Application No: EP/91/21/HH
Site Address: 23 Seaview Road East Preston BN16 1LX
Description of works: Replacement of existing roof including loft conversion and raising of ridge and eaves by 500mm. Dormer to rear roof slope. Alterations to existing external materials. Insertion of new bi-folding doors to rear of property. Construction of new porch.

Thank you for your internet representation made on 19th August 2021 which has been recorded as an objection with the comments as follows:

This drawing is the property of Inspired Design Studio Limited and must not be copied, reproduced or passed to a third party without their permission.

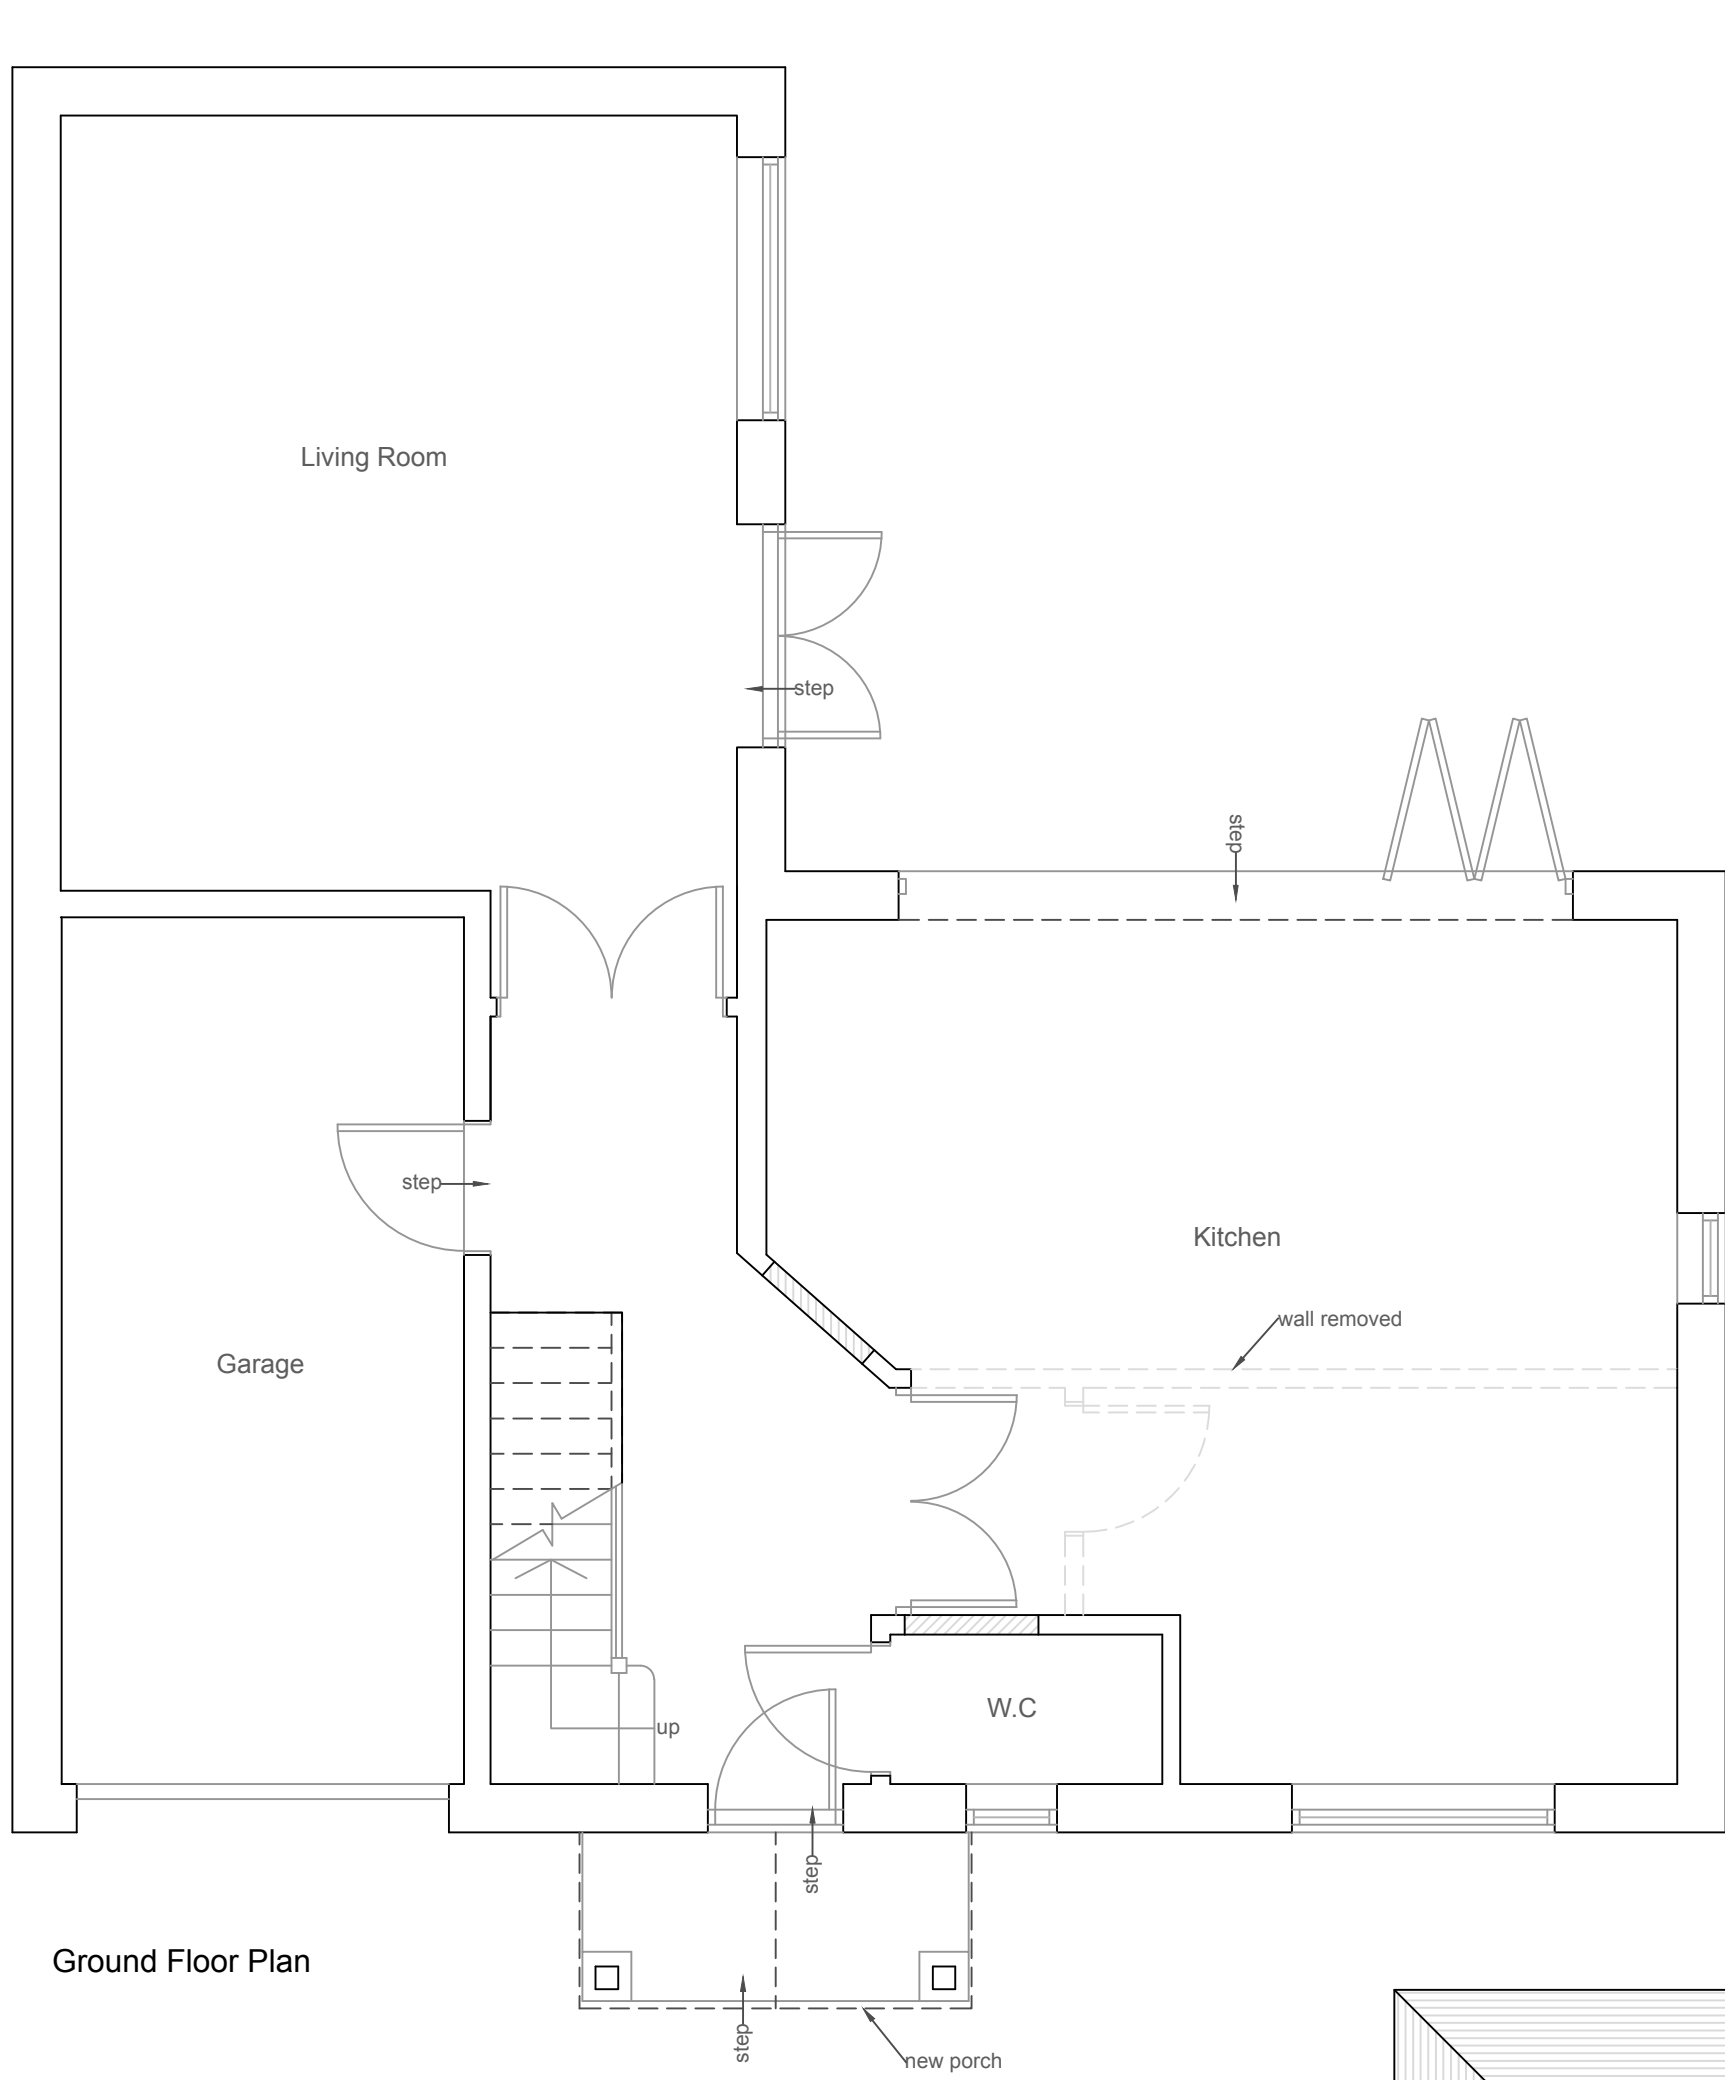
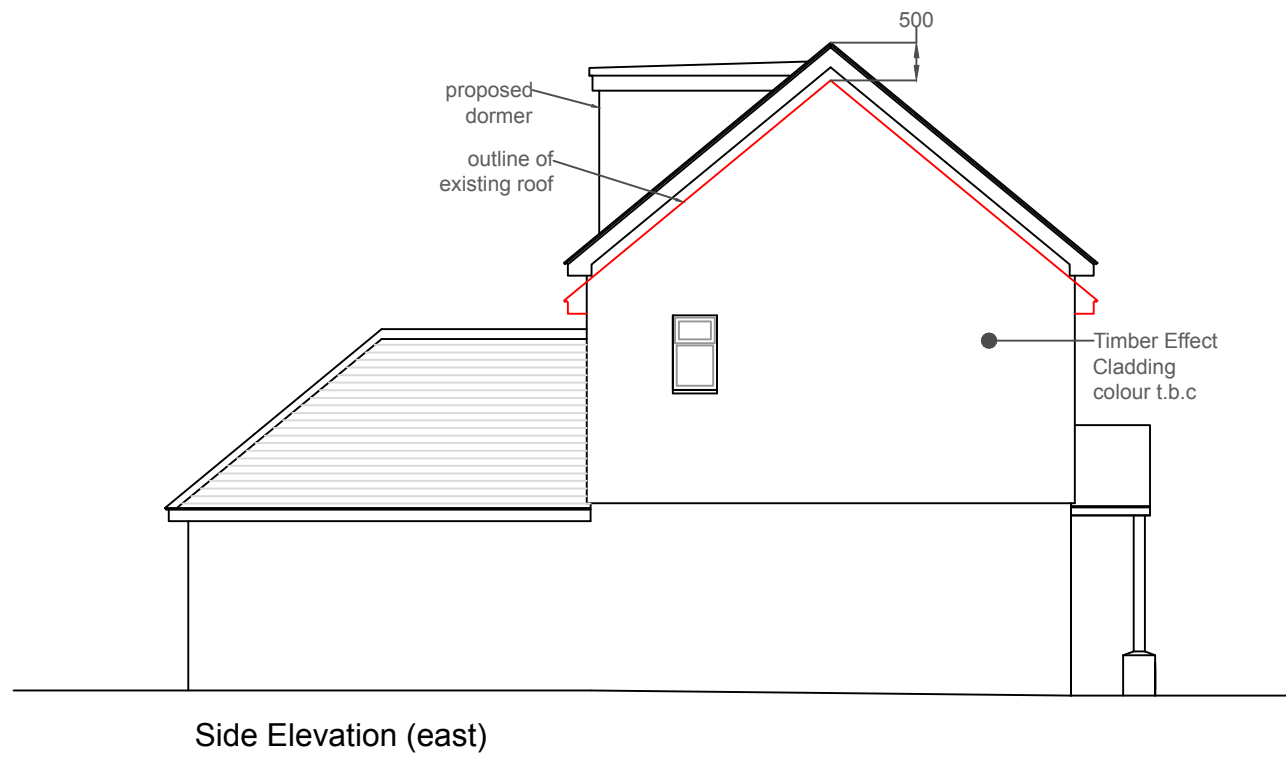
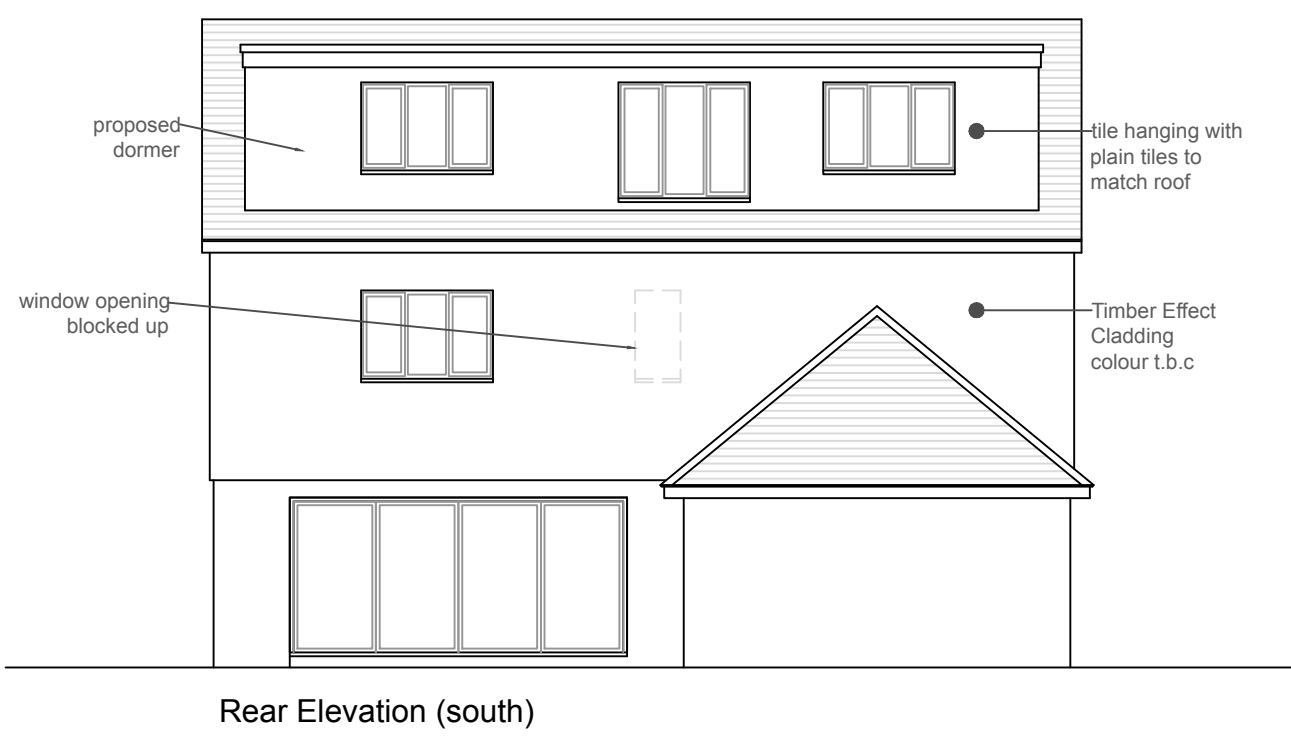
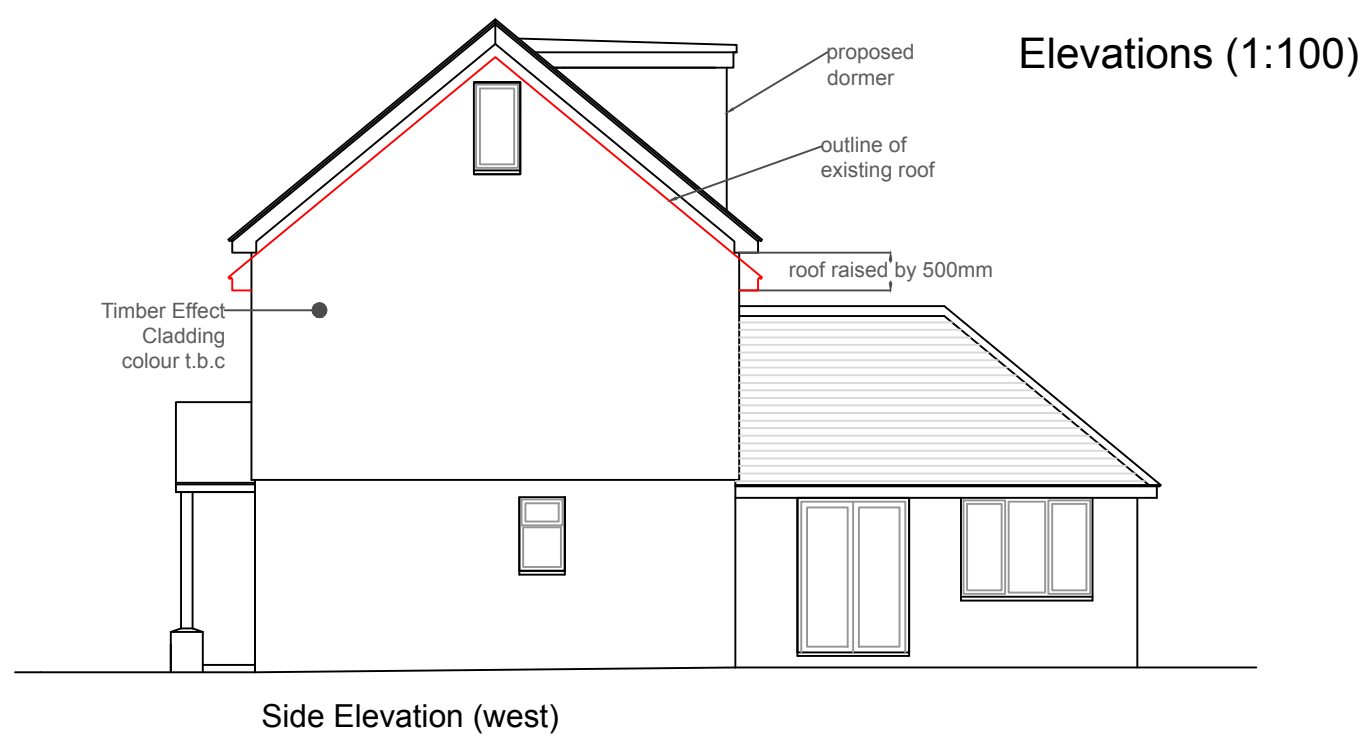
The proposal is to extend a property on a site which we believe is already cramped. Although the footprint of the building does not appear to be increasing, the proposed additional height of the property could result in the site looking overdeveloped.

Whilst the front of the property remains relatively unchanged, the rear elevation will be changed dramatically, resulting in visually a three-storey property, clearly visible from the busy footpath to the west of the site. This council believes the proposal to be contrary to Policy 1: Housing General Principles of the made East Preston Neighbourhood Plan, paragraph 4.14 of which states, New or altered buildings that exceed two storeys in height will rarely be acceptable. Rooms in the roof space may be permitted if the dormer windows are small enough to be subservient to the appearance of the roof as a whole. The proposed almost full-width dormer is unlikely to be considered subservient by many and will leave very little of the pitched roof visible. It is also possible the windows in the proposed dormer will increase overlooking of neighbouring properties and reduce the privacy currently enjoyed by the occupants of those premises.

The provision of a fourth bedroom could result in an increased demand for parking at and around the property. Currently, there appears to be limited on-site parking because of the layout of the area in front of the property. There is no indication this will change so will the revised property be able to provide the required amount of on-site parking. Seaview Road is a very popular road for parking, especially during the summer.

The committee was also concerned about the choice of materials. We do not believe there are any cedar timber-clad buildings within sight of the front of this property.
